Recommendation Report for Planning Permission for Works or Extension to a Dwelling

REF NO: FG/36/22/HH

LOCATION: 166 Littlehampton Road
Ferring
BN12 6PH

PROPOSAL: Two storey side extension, single storey front extension.

Drawing Number: 1488/001 Revision: B1

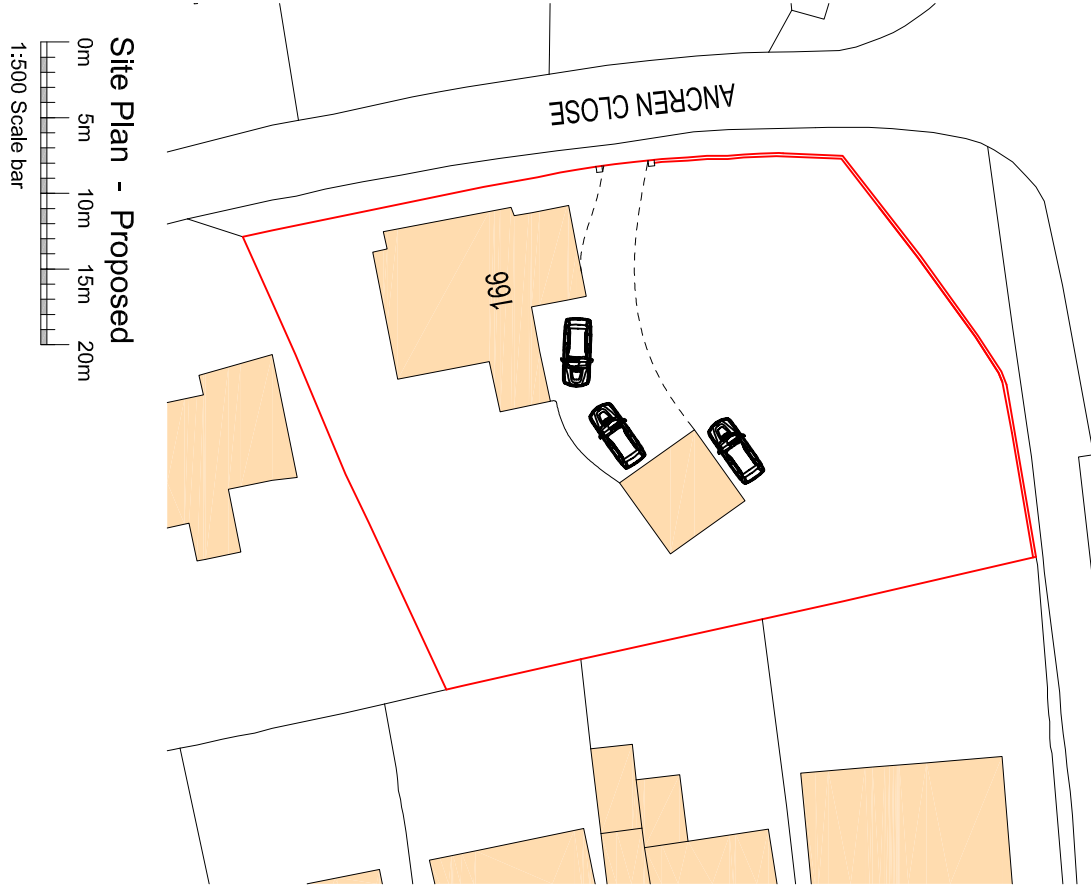
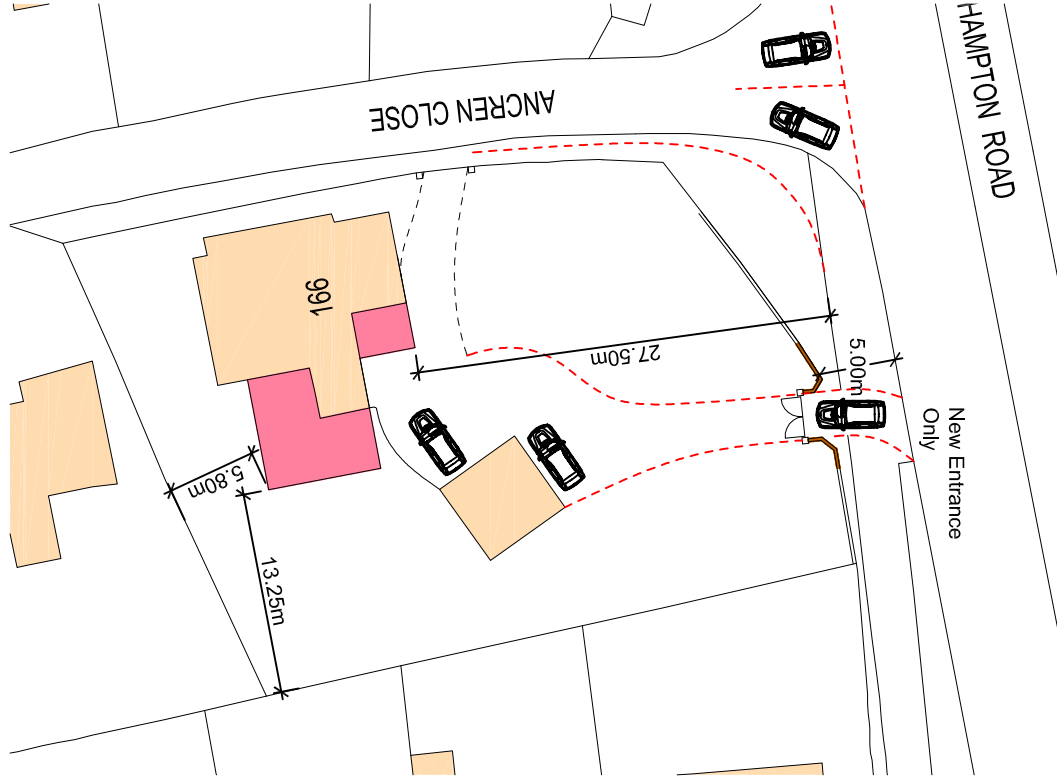
A new access is proposed onto A259 which is subject to a 50 mph speed limit at this point.

It is noted that the plans detail this access as being 'In Only'. There would be no way to formally control that so therefore it has to be considered that the access could be used for movements onto A259 also.

In order to implement the proposed vehicle crossover, The Local Highways Authority would require the existing bus stopping point to be relocated. This will include physically moving the stopping point, repainting the bus cage markings, constructing / reconstructing any hardstanding as required.

Given the site already benefits from adequate vehicle access via Ancren Close the applicant may wish to consider removing the vehicle crossover works from the application and seek only the domestic extension works.

The Applicant has removed the proposed highways access onto the Littlehampton Road from the application.

Drawing Number: Revision:
1488/001 C1

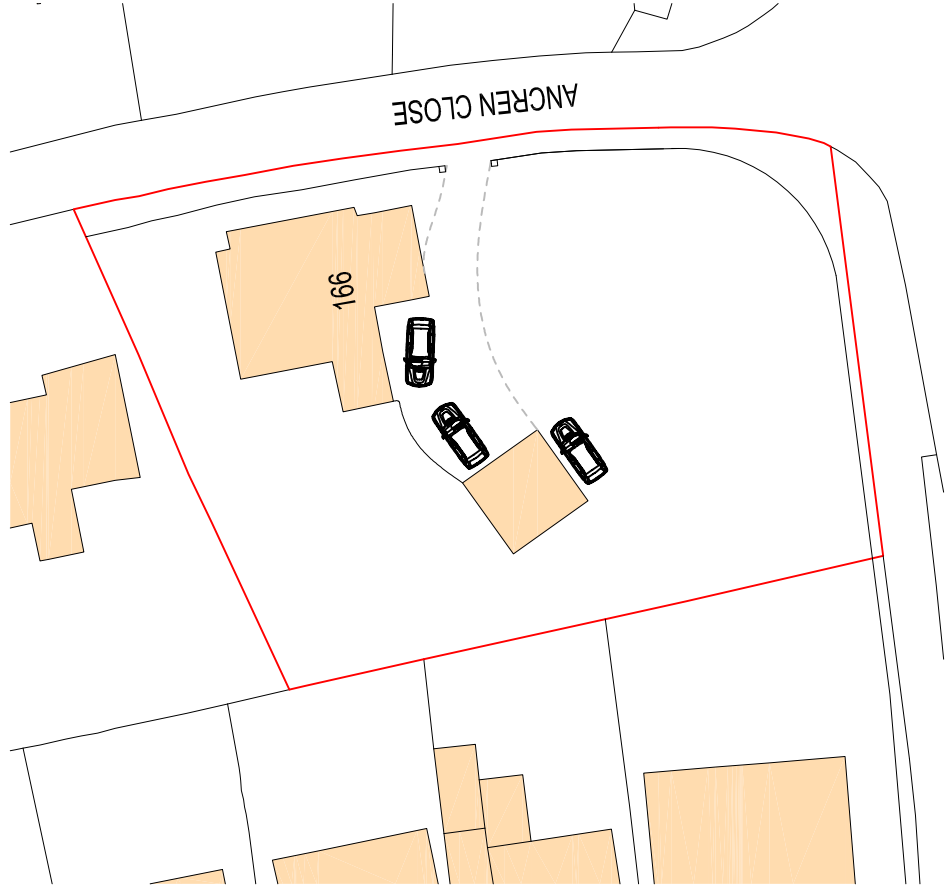
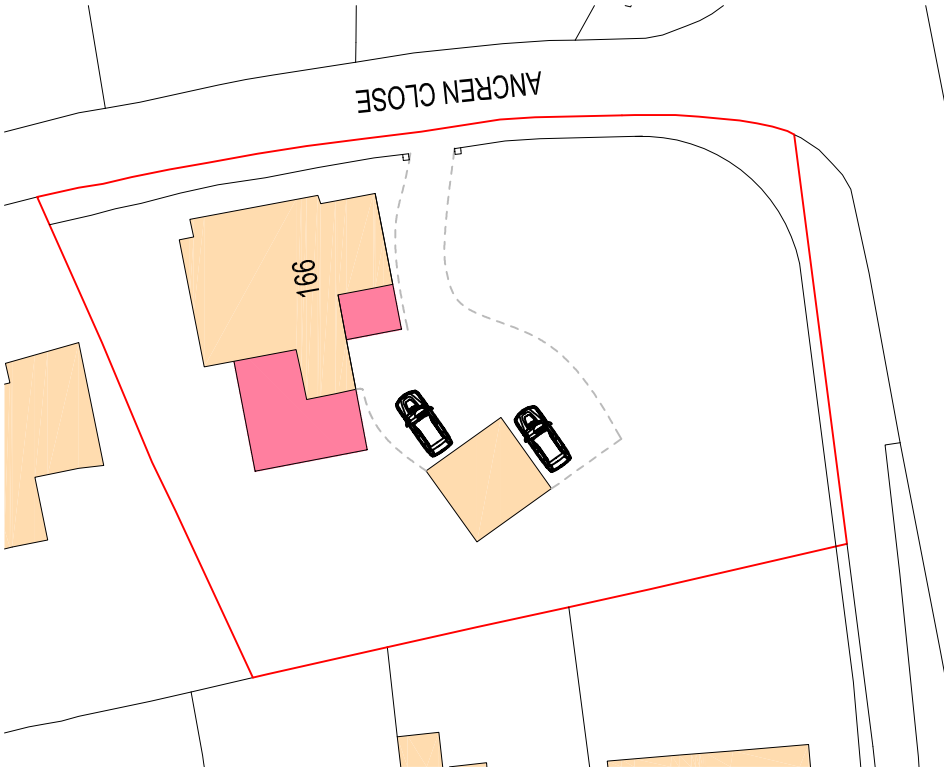
as a planning permission would be required to alter its position. New plans were submitted to rectify this. However, it is still noted that the northern boundary line to plan 1488/001 C1, does not show its original position. It is to be noted that this permission does not relate to any amendments to the position of the fence line, it is for the works as set out within the description only.

- 5 INFORMATIVE: This permission relates to the works as set out within the description (Two storey side extension, single storey front extension) and does not include alterations to the northern boundary line. Should the applicant wish to amend the boundary line then written permission from the Local Planning Authority would be required before works were undertaken.
